Subject: Response to REP14-010

Response to REP14-010

FIGURE 7.6B
RETENTION OF
EXISTING VEGETATION
AND TREES

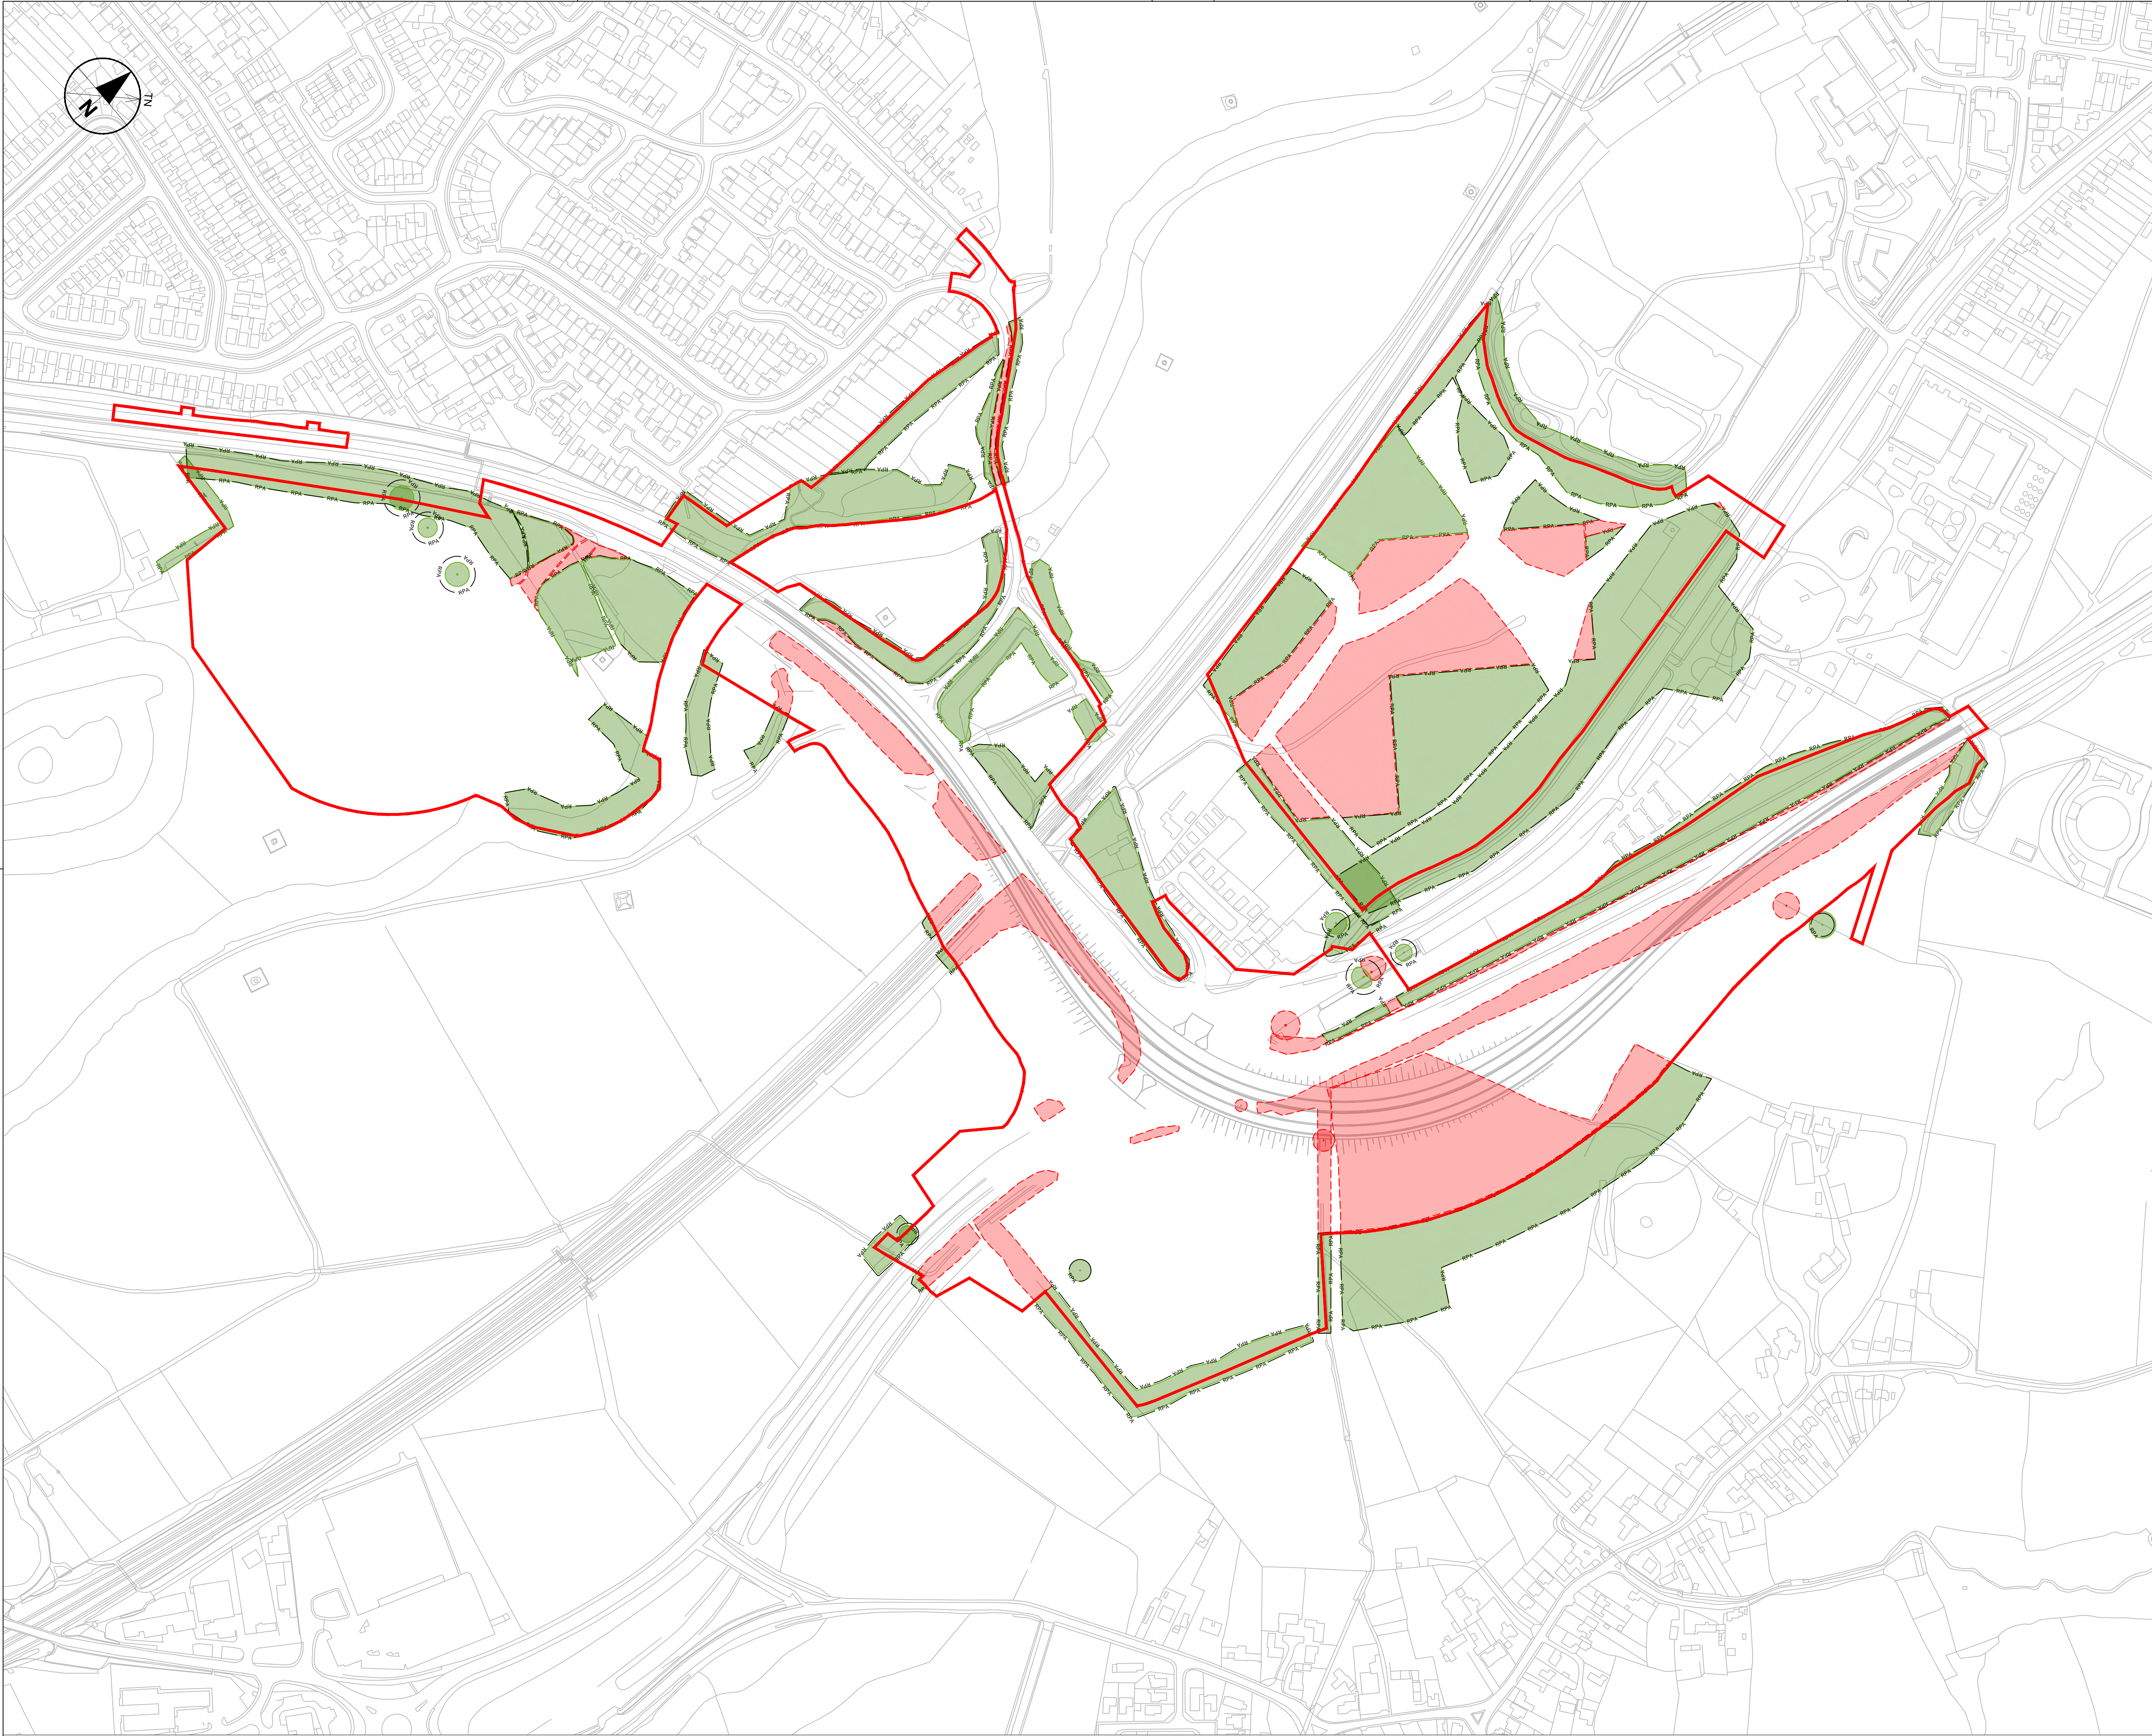
In Appendix 7 of 6.14 Environmental Statement Addendum, HE state various reasons for not being able to save the ancient oak T358. The only limitation there appears to be to allow movement of things like Statutory Undertakers corridors and drainage ditches, which currently cut through the RPA, is the Limits of Deviation that have been set “to optimise land use within the Order limits and to minimise impacts from the Scheme.” Surely the LoD could be reassessed for this particular area of the scheme to allow these bits of infrastructure to be diverted away from this tree. That together with a redesign/slight change in position of the bridge could allow this important tree to survive? Surely it isn't beyond the abilities of HE to do this?
